Your ref: SSD- 73910208
Our ref: DOC25/678373

Subject: Major Projects – New Request for Advice – Seniors Housing – IRT Woonona Redevelopment (SSD- 73910208) (Wollongong City)

Attachment A – CPHR Detailed Comments – 4-6 Popes Road Woonona IRT redevelopment (SSD- 73910208)

FIGURE F58

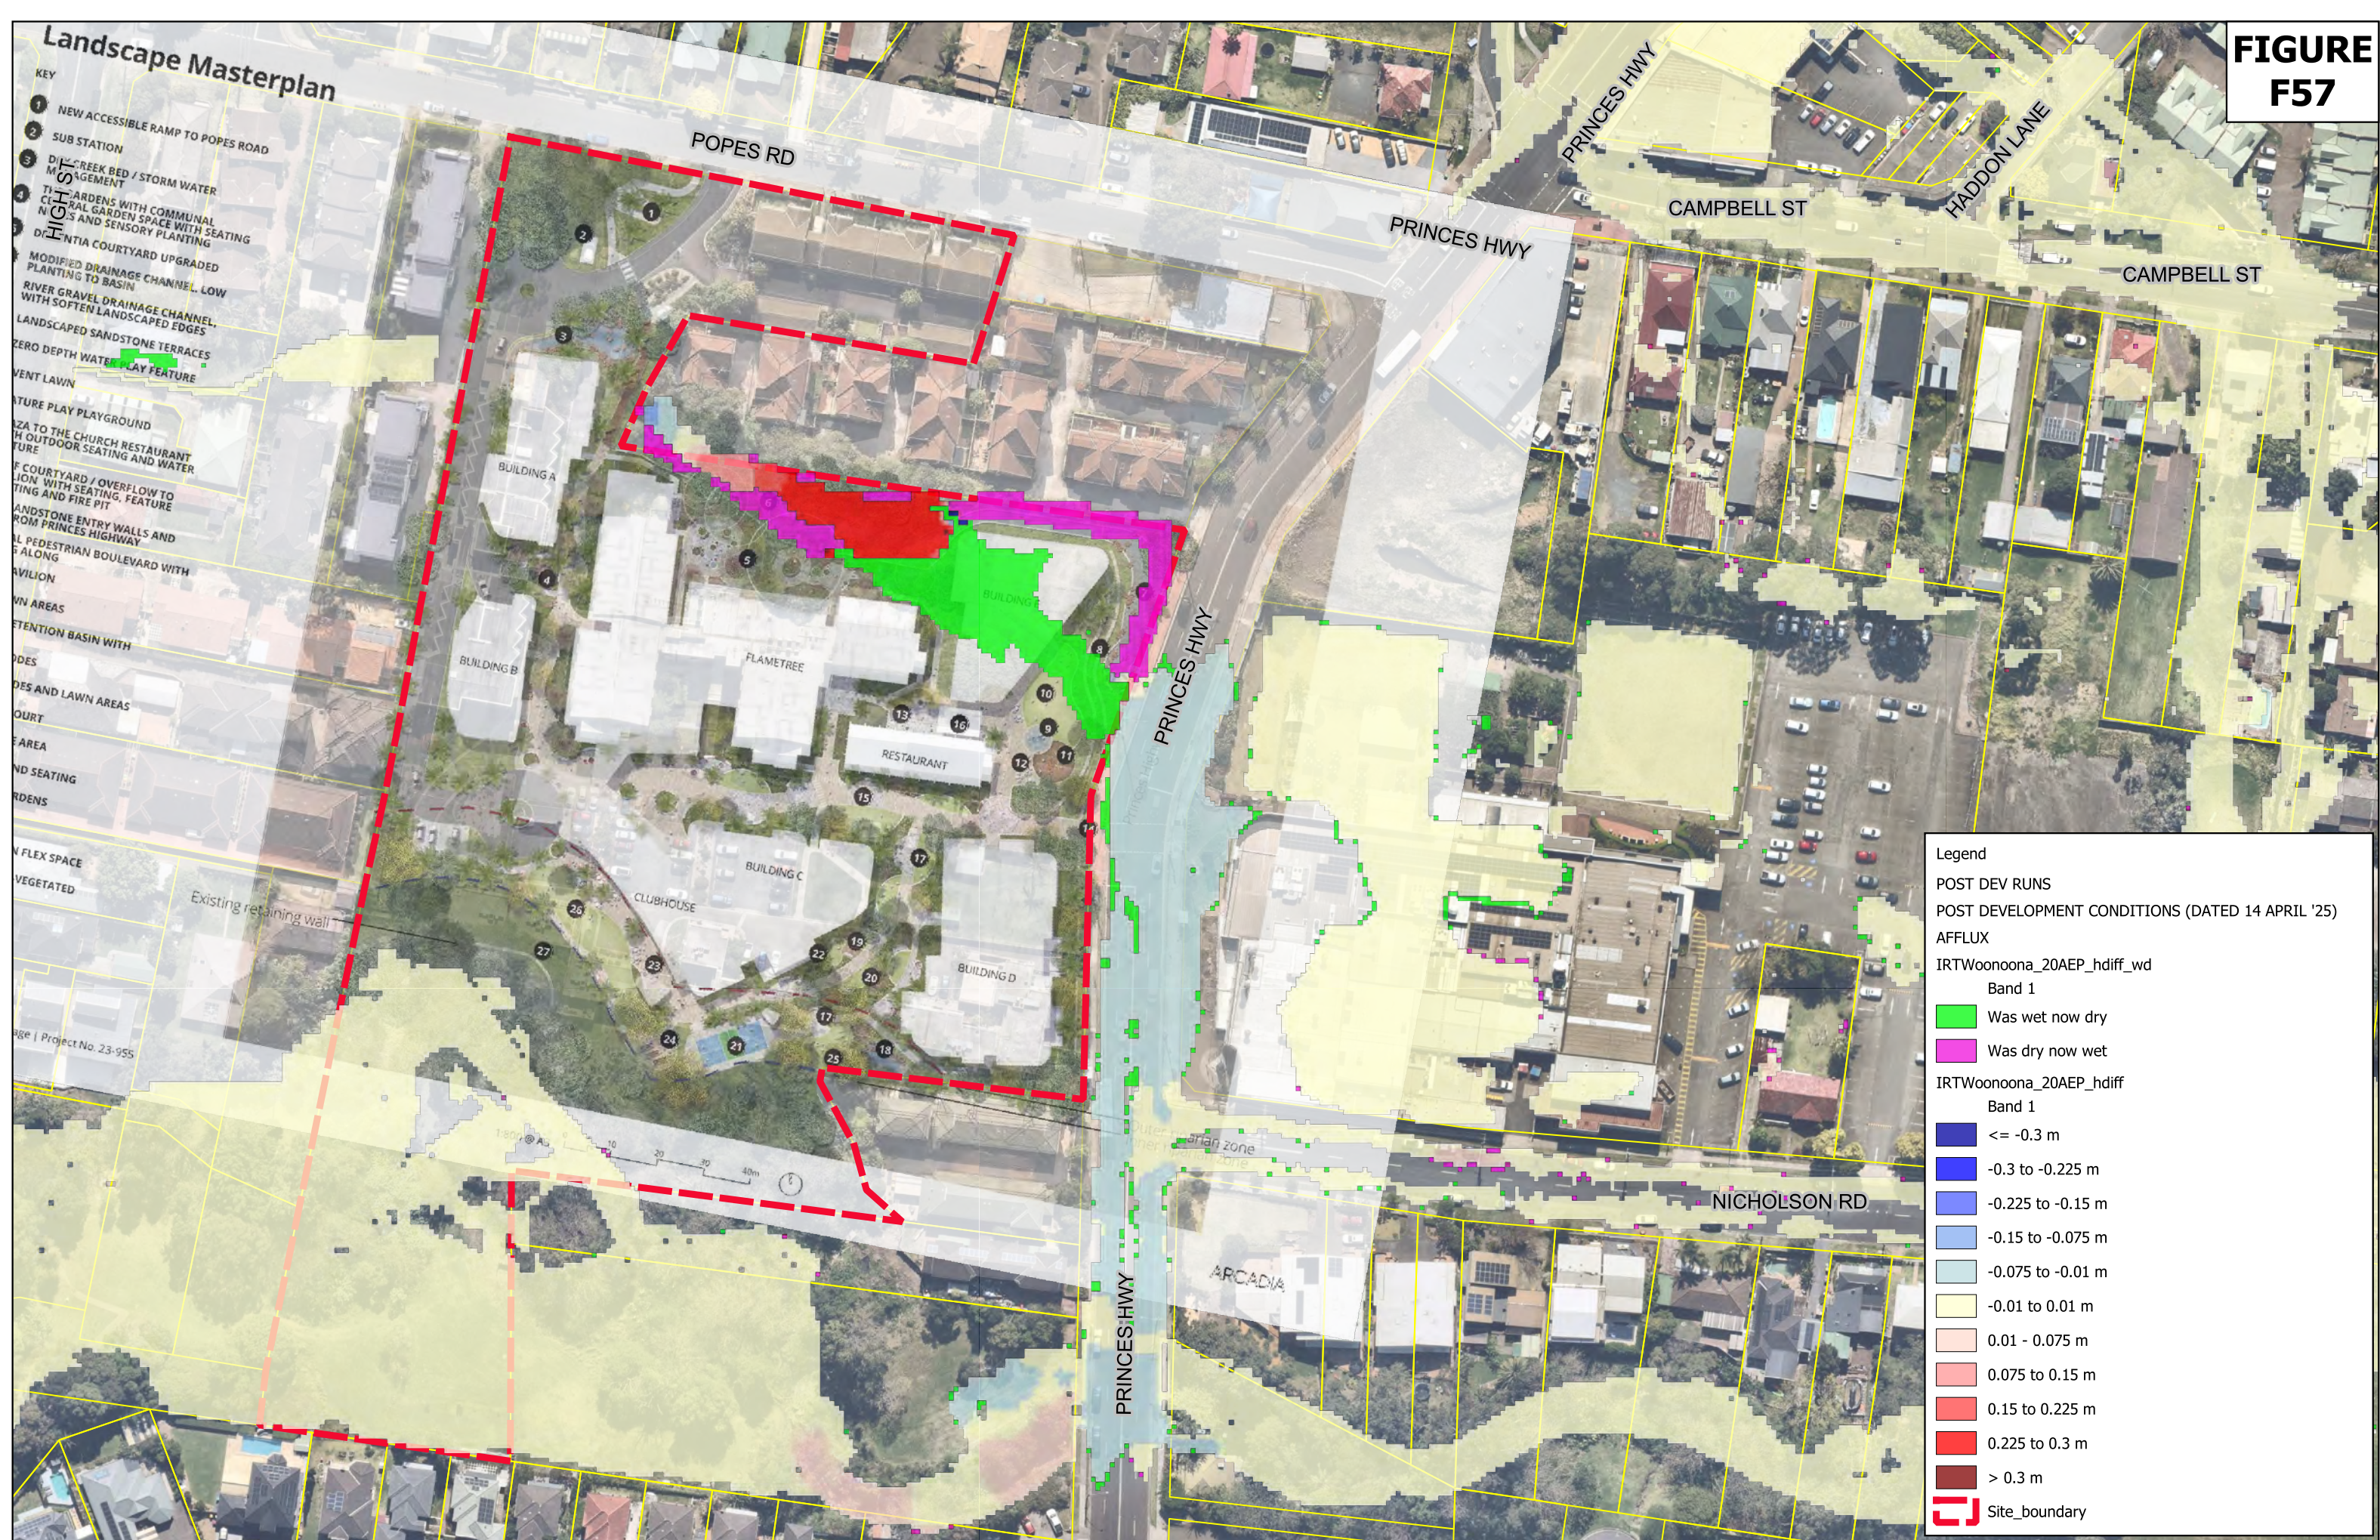
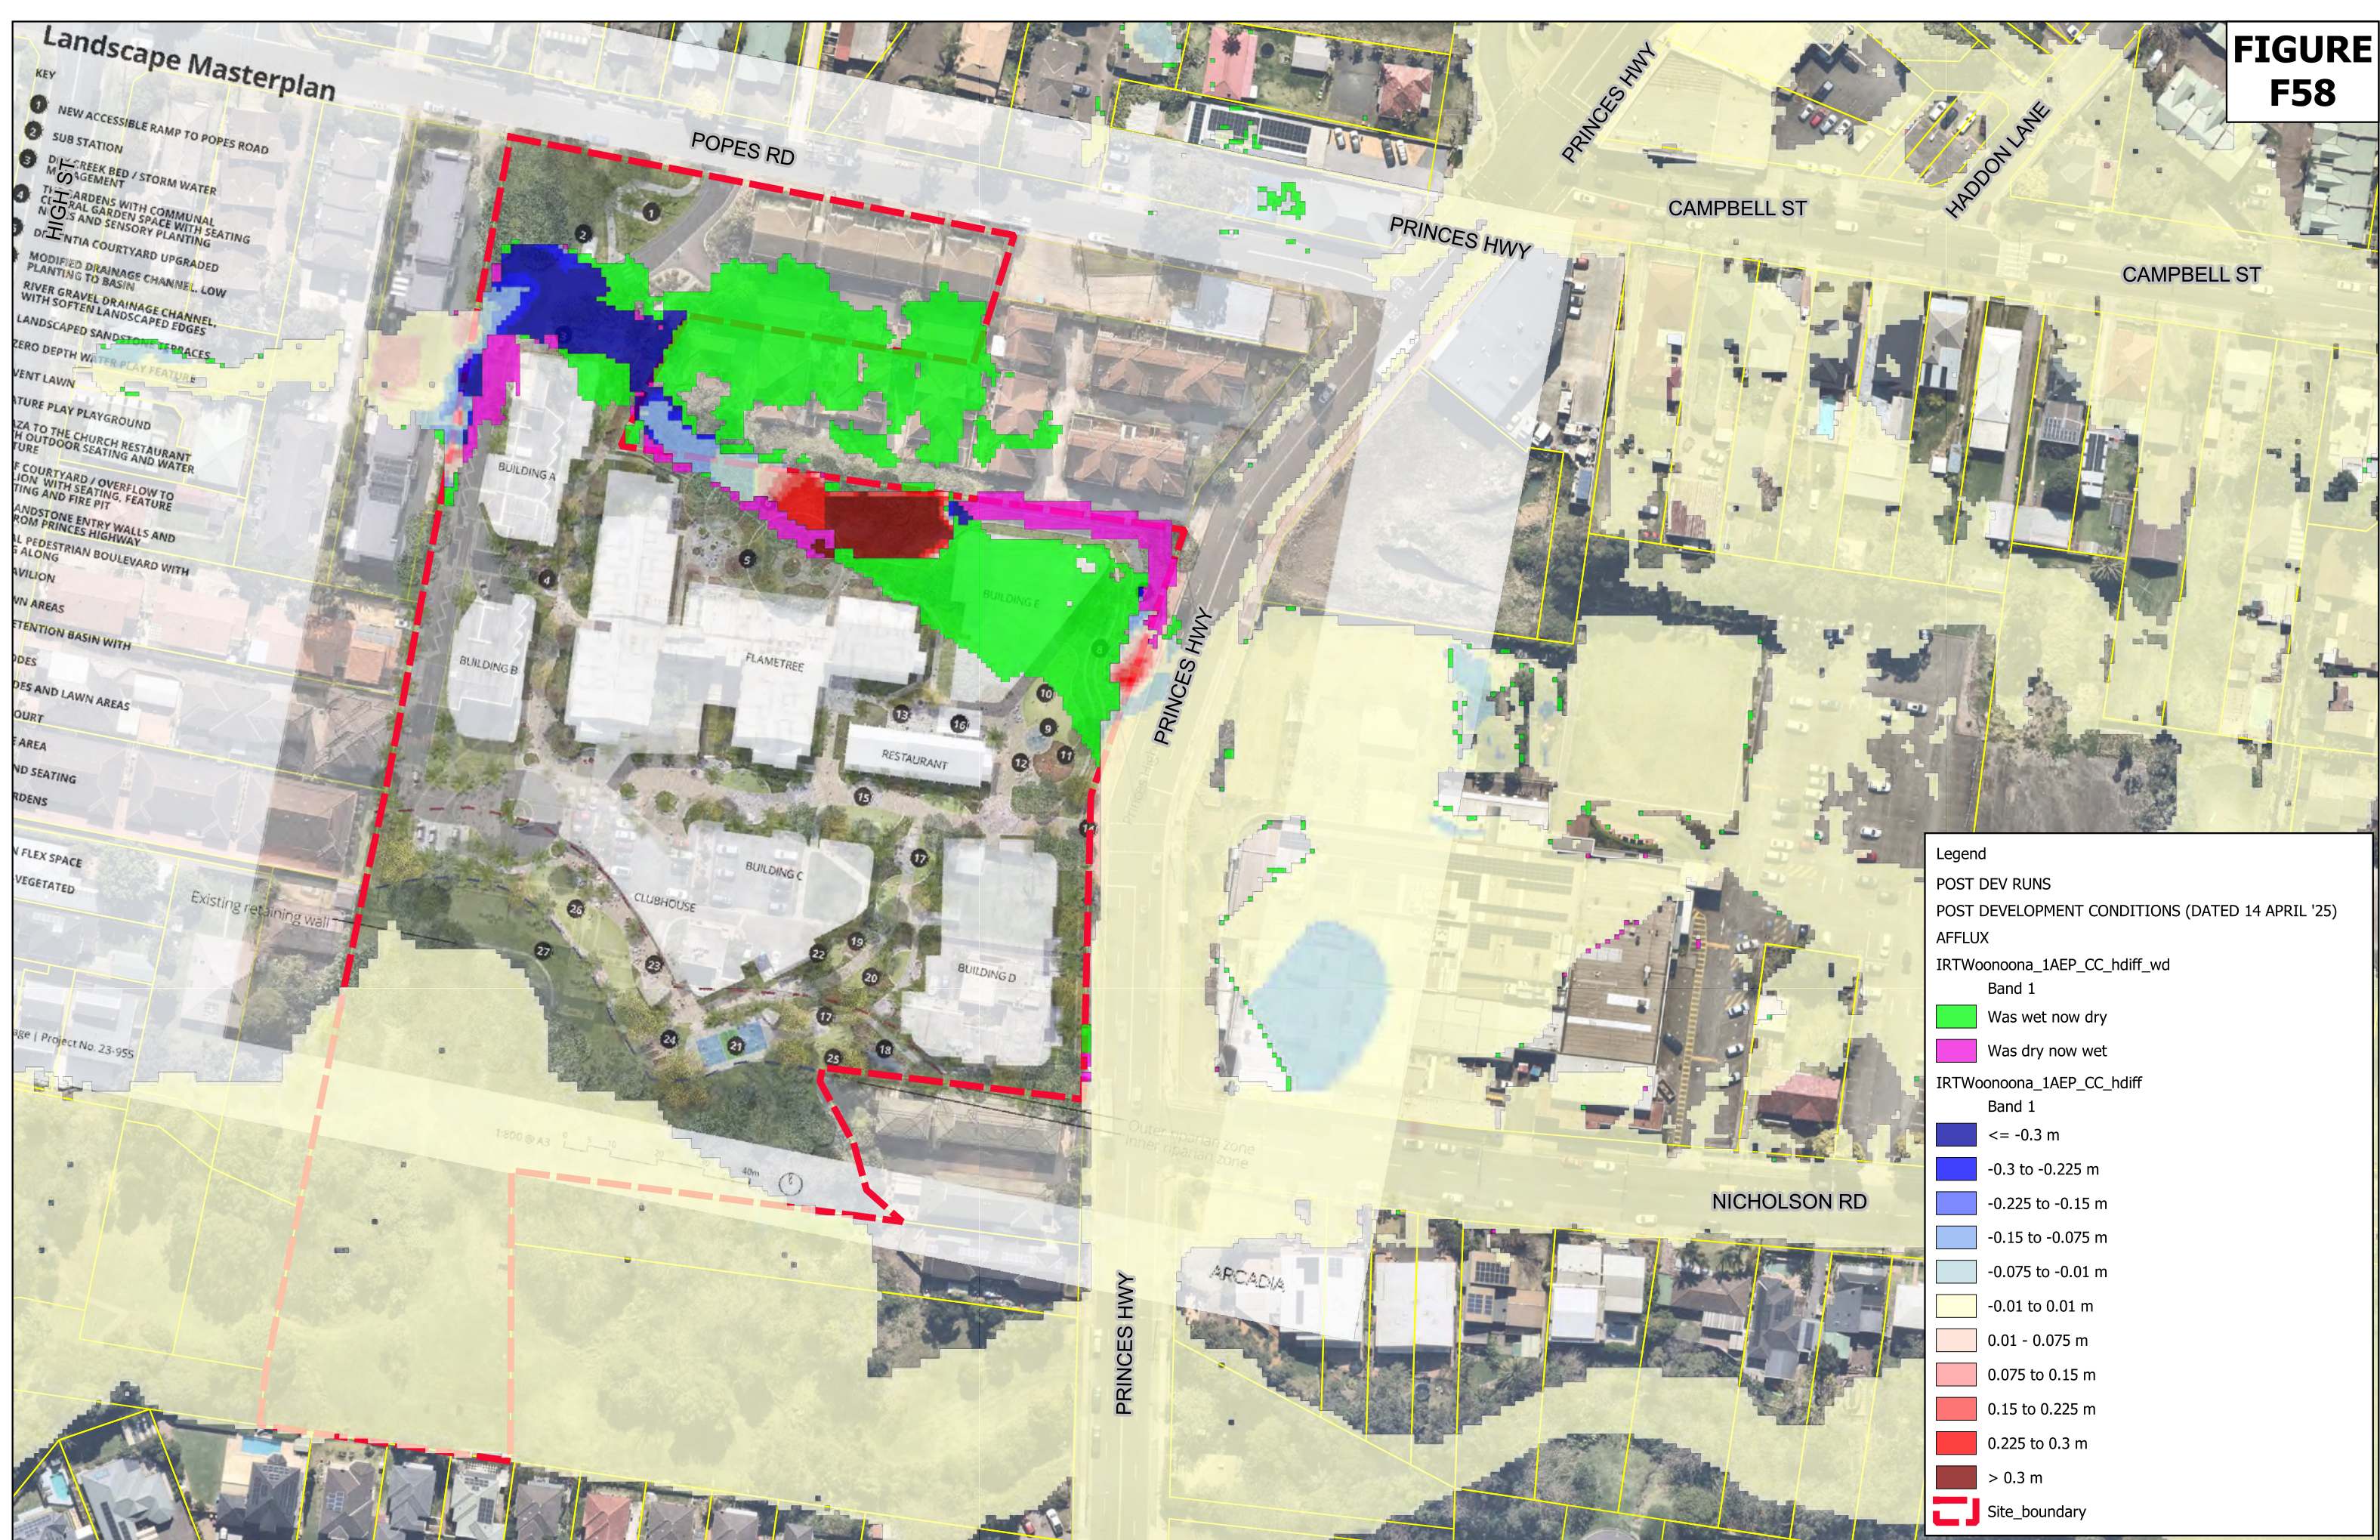
The flood risk impact assessment maps (Figures F53 & F55 to F58) provided in the Flood Report (Acor Consulting, May 2025) identifies adverse flood impacts on Nicholson Road and Collins Creek in the 20% AEP event, and on the Princes Highway from the 10% AEP. The Probable Maximum Flood (PMF) velocity maps (Figures F32 & F61) identify several residential properties along Nicholson Road and the Woonona Bulli RSL Club that were previously not flood affected are shown to be inundated. This information makes it difficult for the determining authority to be satisfied that the adverse offsite flood impacts will be managed on-site. This issue should be resolved including any modifications to the proposed flow paths, flood storage and hydraulic structures (such as the proposed spillway) to ensure that the proposed development does not cause adverse off-site flood impacts and associated liabilities whilst still meeting its intended flood design outcomes for the new development.

As Wollongong City Council (council) is the local authority responsible for flood risk management and holds the most up to date flood information at this site, it is recommended that they be consulted to ensure that the adverse impact assessment issues identified above aligns with the requirements of council's flood related development controls. This should include managing adverse flood and stormwater impacts and flood related public safety requirements. It is noted that the Flood Report concludes that the PMF with a freeboard will be used as the Flood Planning Level (FPL) to meet council's development controls. Whilst this avoids the need for evacuation of vulnerable residents, the Flood Report should still establish that the proposed FPL is greater than the Design Flood Event, which is the 1% AEP plus climate change currently required by council.
